Request for advice on EIS

Central Sydney Industrial Estate incorporating the Sustainable Road Resource Centre

SSD-10459

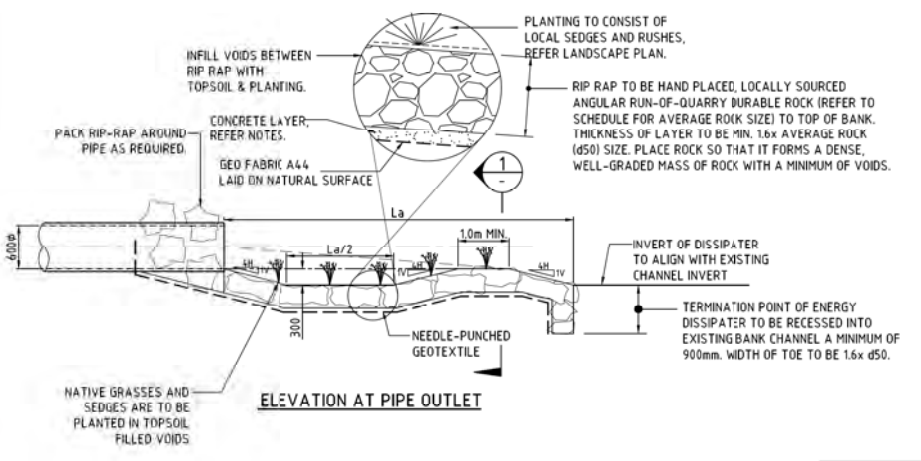
4. DPI Fisheries requests the engineering specifications and expected flow rates of the Duck Creek outlets to assess the impact on existing protected mangrove forests. The outlet that services the retention pond is directly adjacent the widest part of the existing riparian vegetation. DPI Fisheries request that this outlet be moved to an area that is of a lower ecological value.

Drawing Title:
Riparian Corridor Section B-B
 DWG No: **SSD-09**

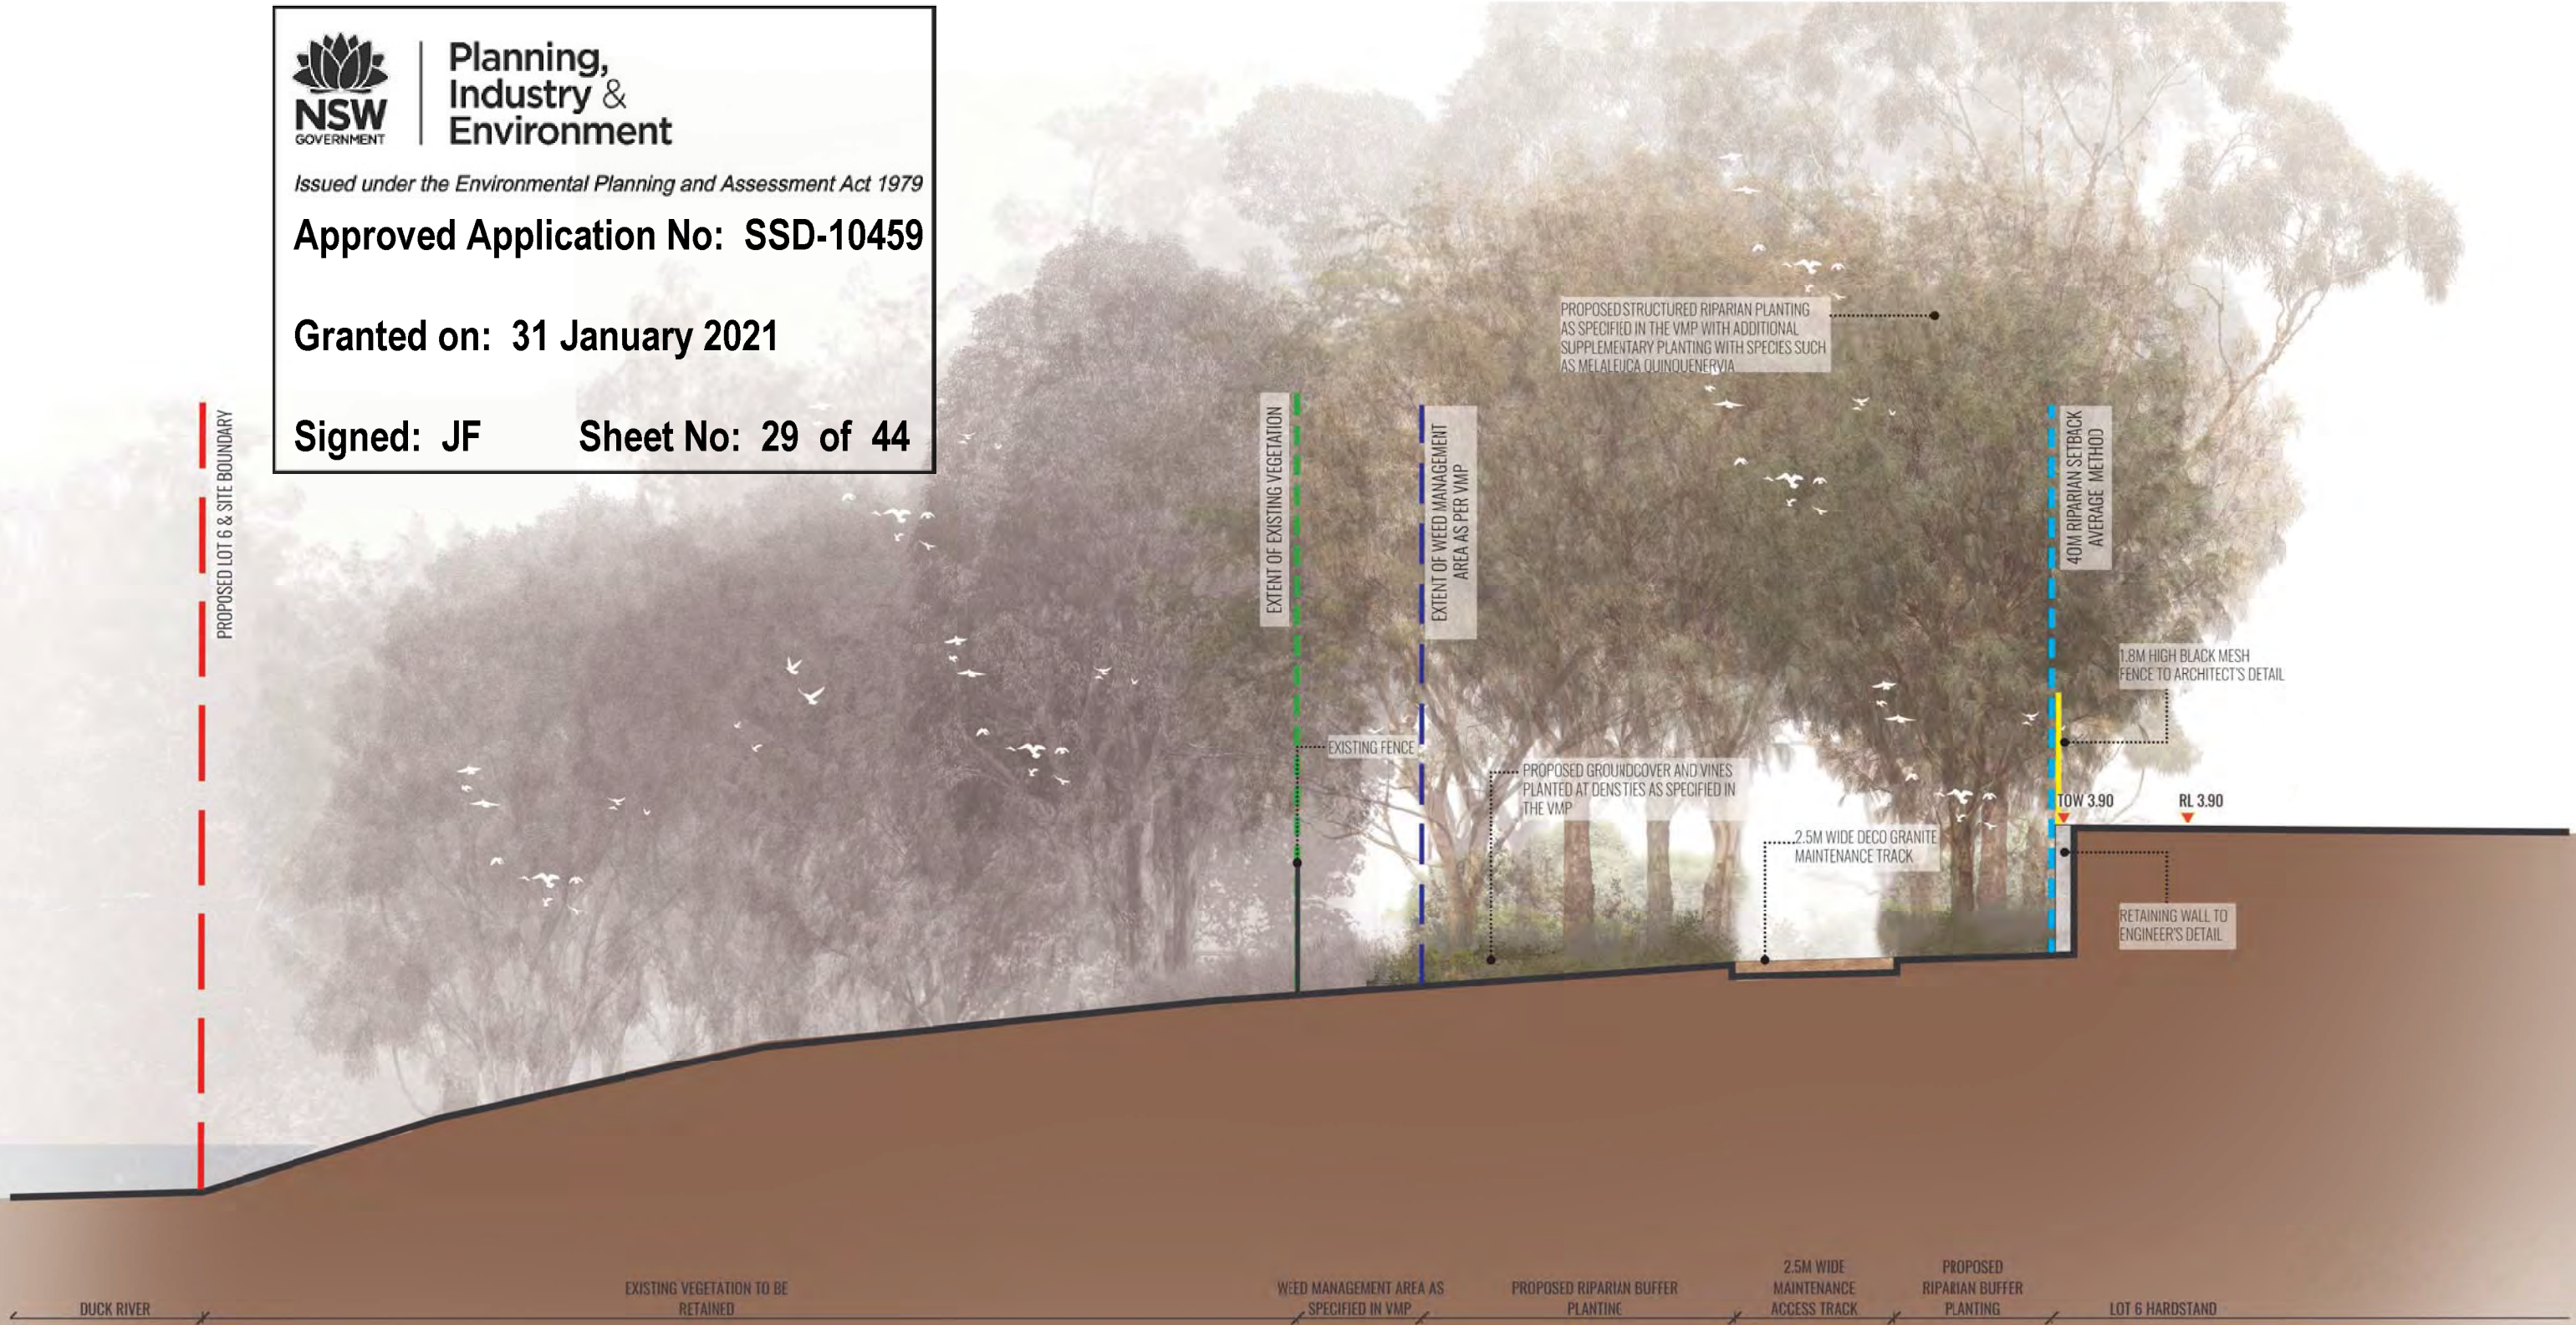
3. A 2.5m road proposed through the riparian corridor negates the effectiveness of the corridor as an environmental mitigation. DPI Fisheries does not support the road through the riparian corridor. DPI Fisheries also seeks further information about the extent and purpose of the retaining wall adjacent to the riparian corridor. Generally, retaining walls have a negative effect on the environmental value of a riparian zone.
